Planning Act 2008 and The Infrastructure Planning (Examination Procedure) Rules 2010 Application by AQUIND Limited for an Order granting Development Consent for the proposed AQUIND Interconnector (“the AQUIND Interconnector project”)

Secretary of State Consultation No. 3

Unique Reference: EN020022

Invitation from Secretary of State to respond to third set of information presented by applicant

DRAWING No: EN020022-2.6-PARA-Sheet3	REV: 02
--------------------------------------	---------

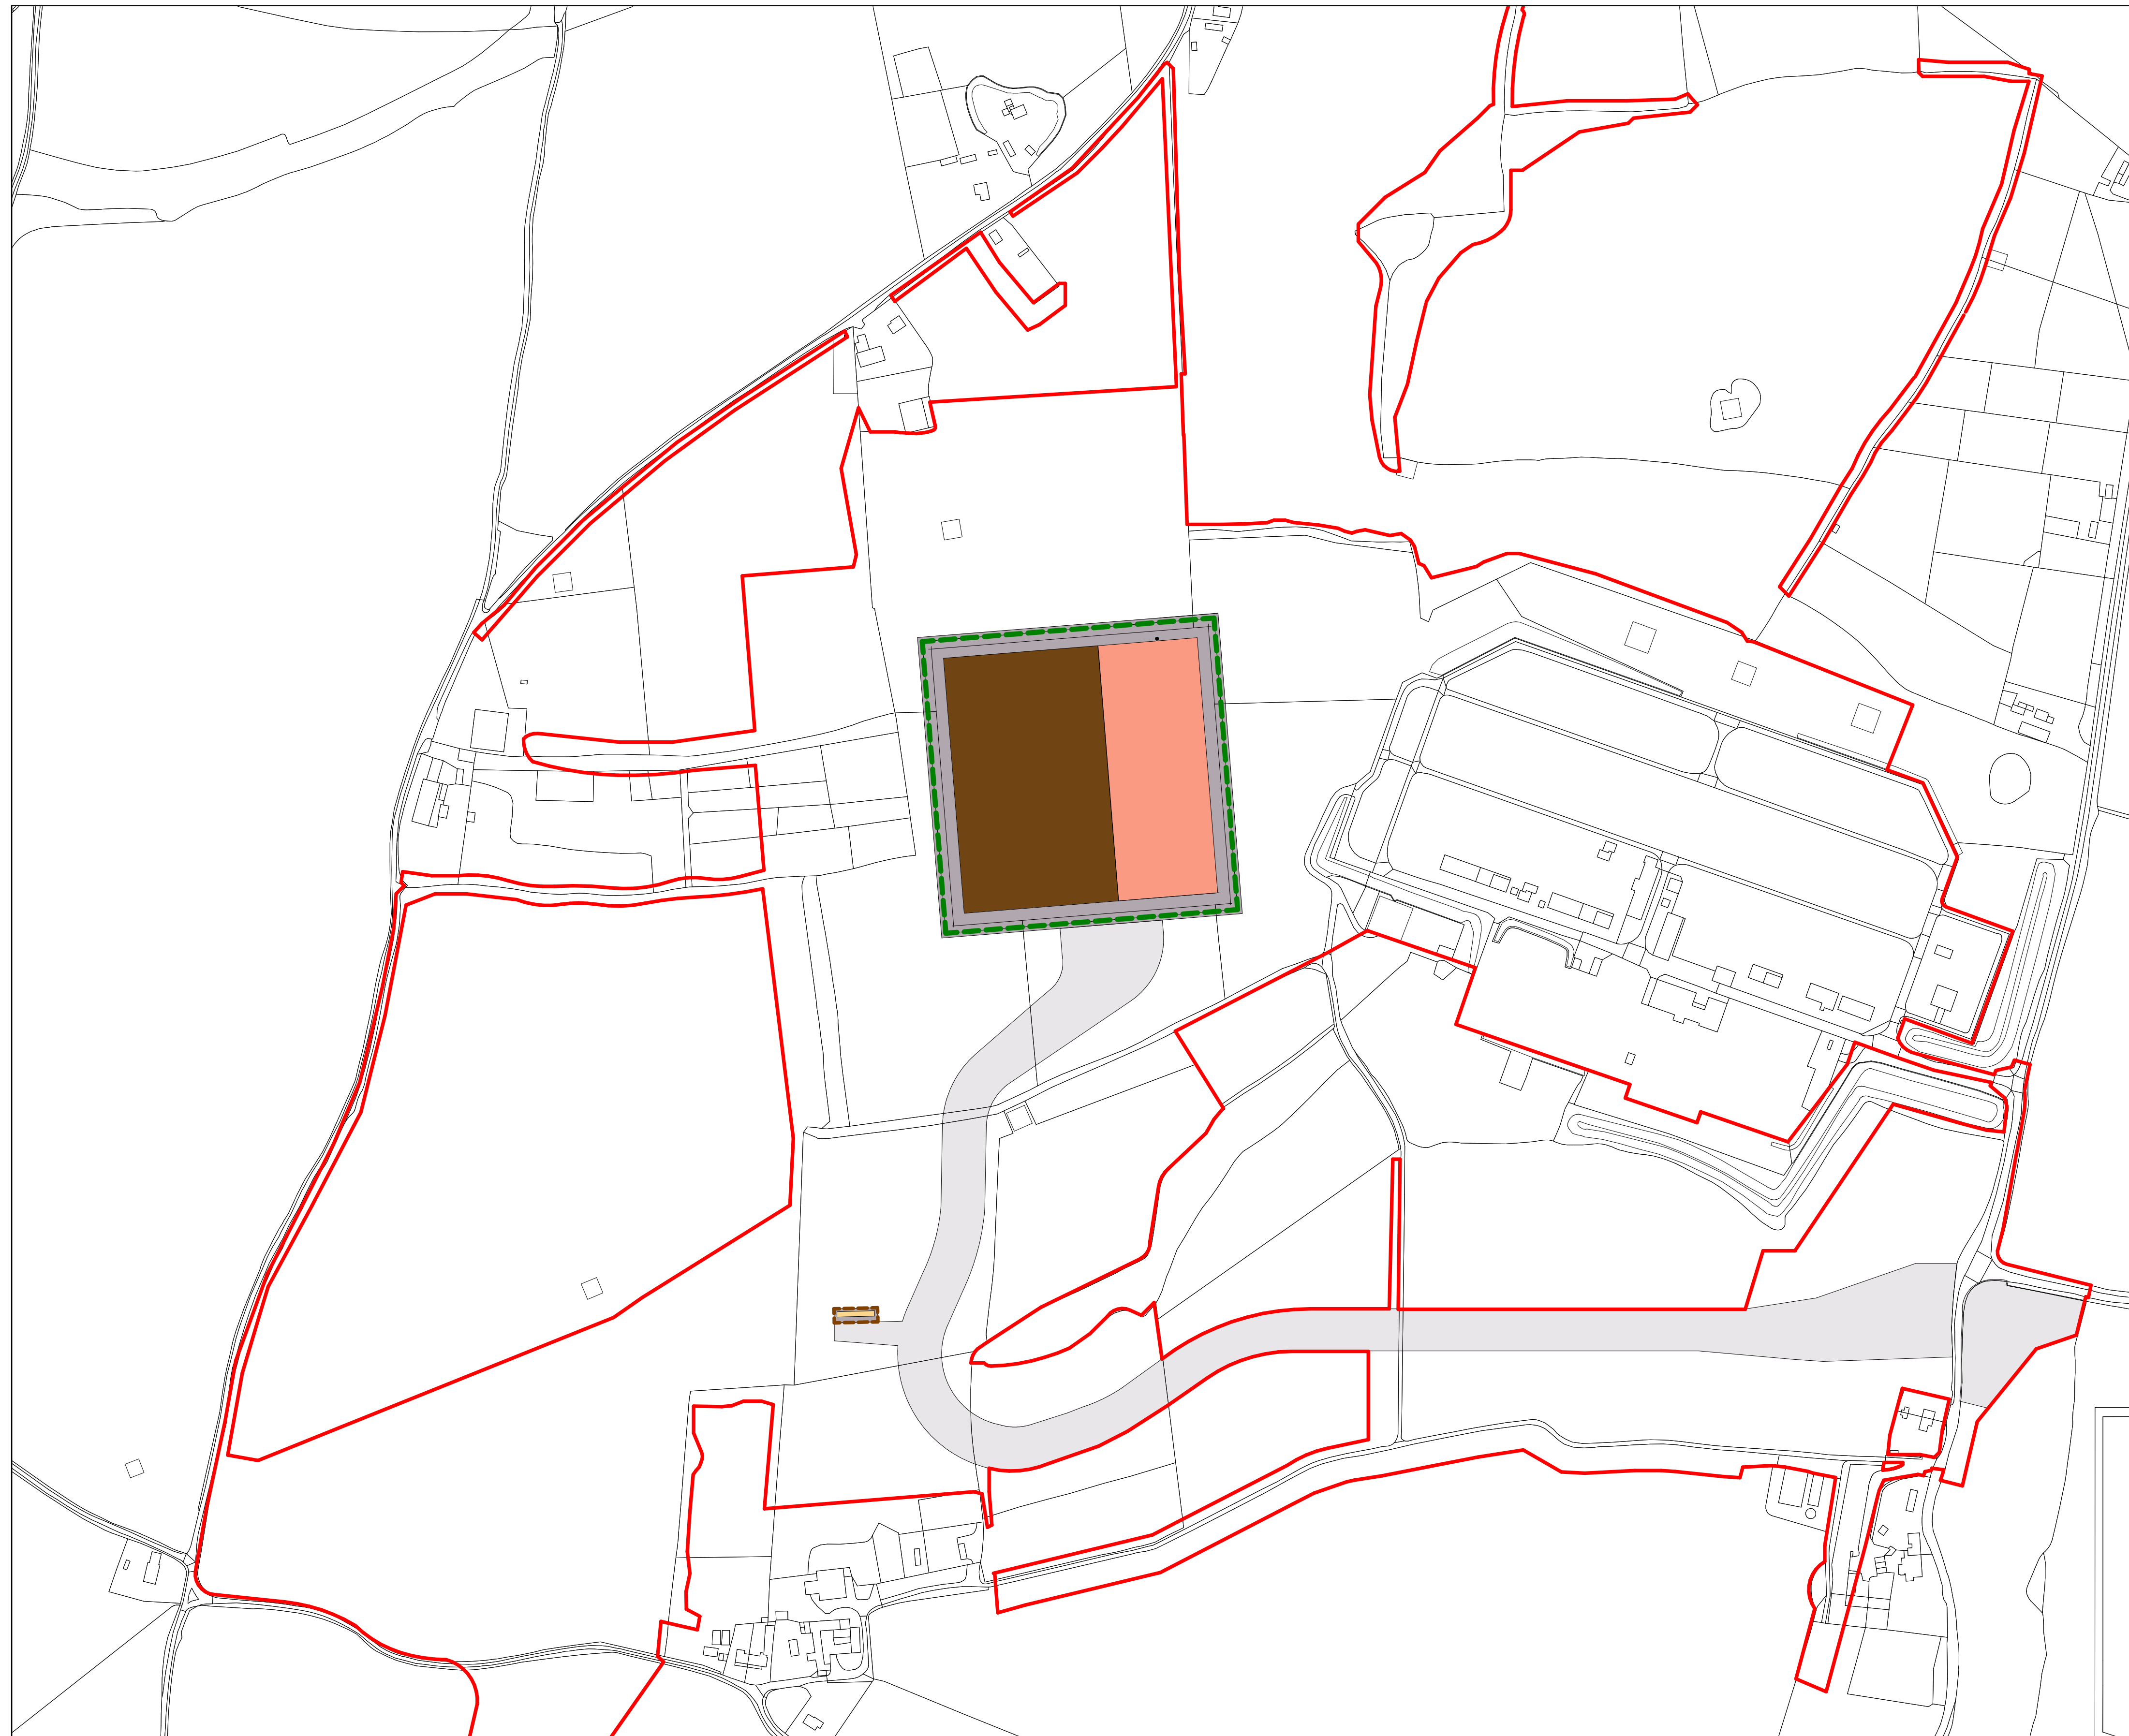
The Council does not wish to see the dDCO go forward with the two options but wishes the ExA to strike out option B(i). Accordingly, requirement 4 needs revising to reflect this. The following wording is offered but the Council will accept any alternative that achieves the same outcome:

For the avoidance of any doubt, the Converter Station shall only be constructed in accordance with the perimeter area that is referred to as option B(ii) on the converter station and telecommunications building parameter plan drawing number EN020022-2.6-PARA-Sheet 3 rev02 as listed in Schedule 7 to the Order.
